Morris Goding  
Access Consulting

**St Matthew's  
Catholic High  
School Mudgee  
School**

21<sup>st</sup> April 2020

Morris Goding Access Consulting (MGAC) has reviewed the Detailed Design Documentation for St Matthew's Catholic School, Mudgee.

CARPARK LINE MARKING SETOUT PLAN

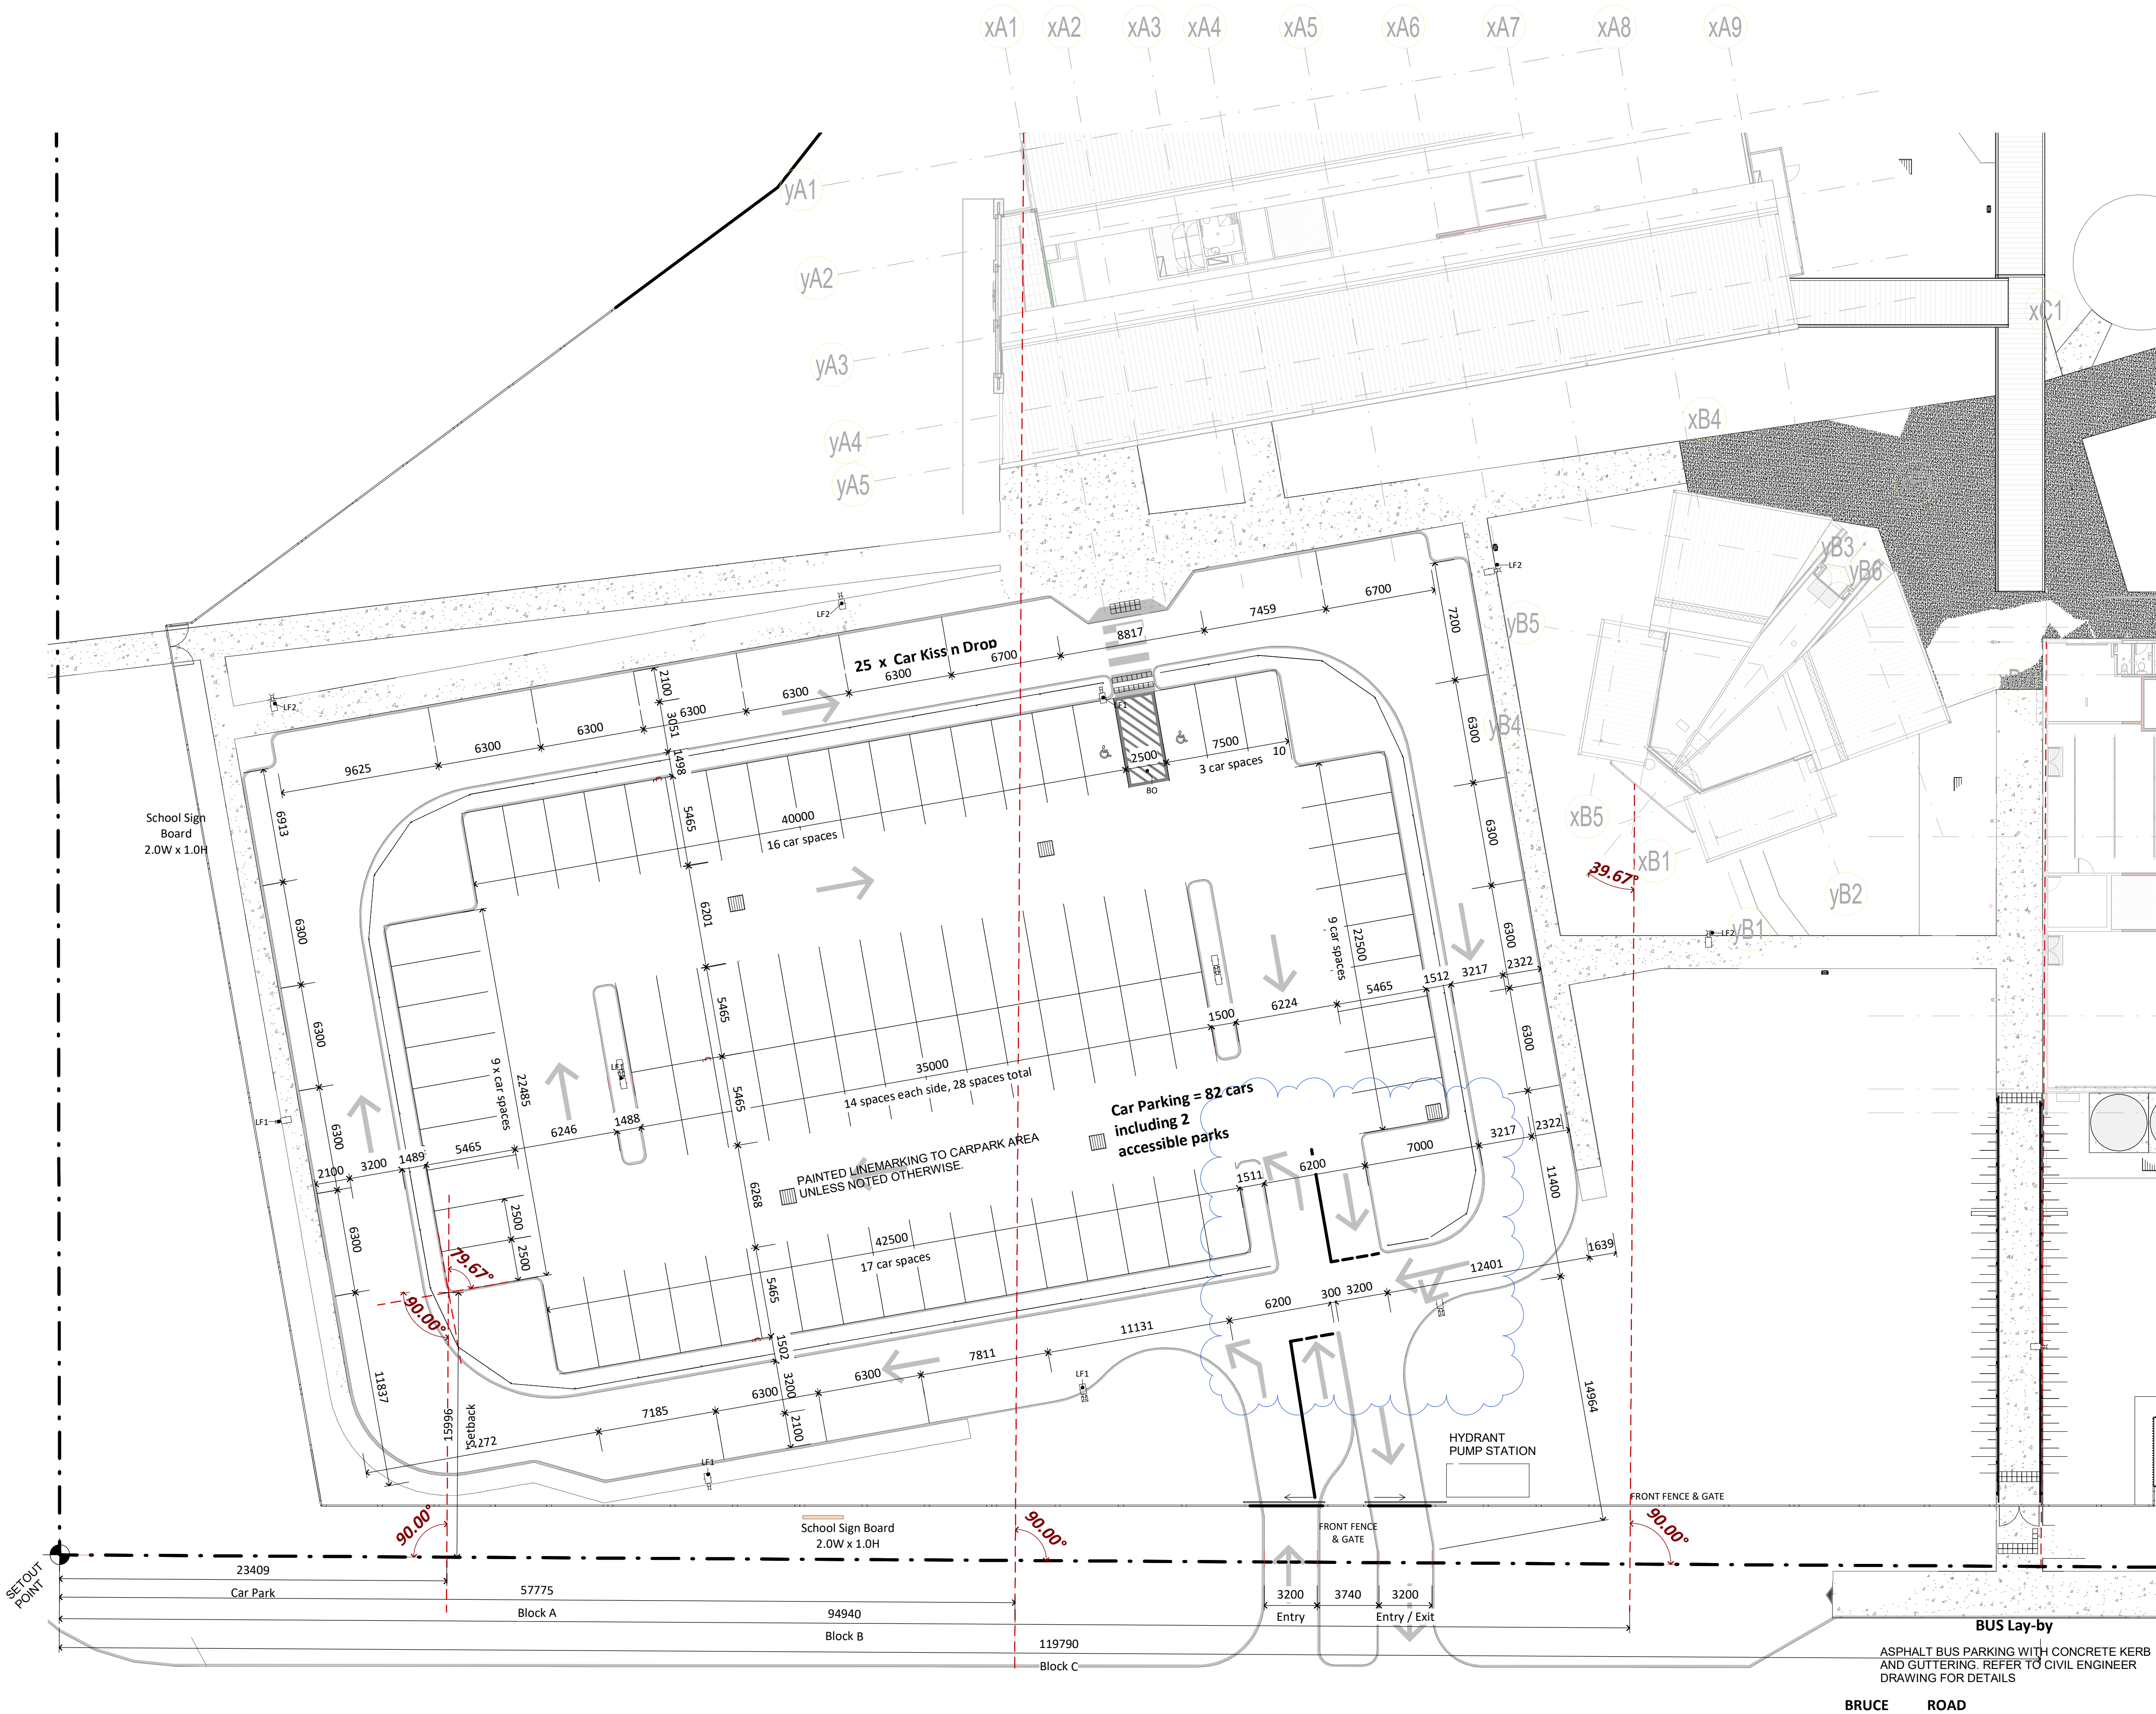
20.1.	Documentation does not show vertical heights at car bays.	Under AS2890.6, 2.5 metre vertical clearance is required at accessible car bay and shared zone. There needs to be 2.2 metre vertical clearance leading to accessible car bays.	<b>OPEN</b>

20.2.	Drawing need to provide higher details showing car allocation breakdowns. See MGAC drawing comments.	Provide allocations for staff, students, visitors, and any other breakdowns, and ensure 1x accessible car space is provided per 100 spaces (or part thereof) for each type of car space breakdown/allocation greater than 5. Drawings indicate compliance can be achieved however finer details
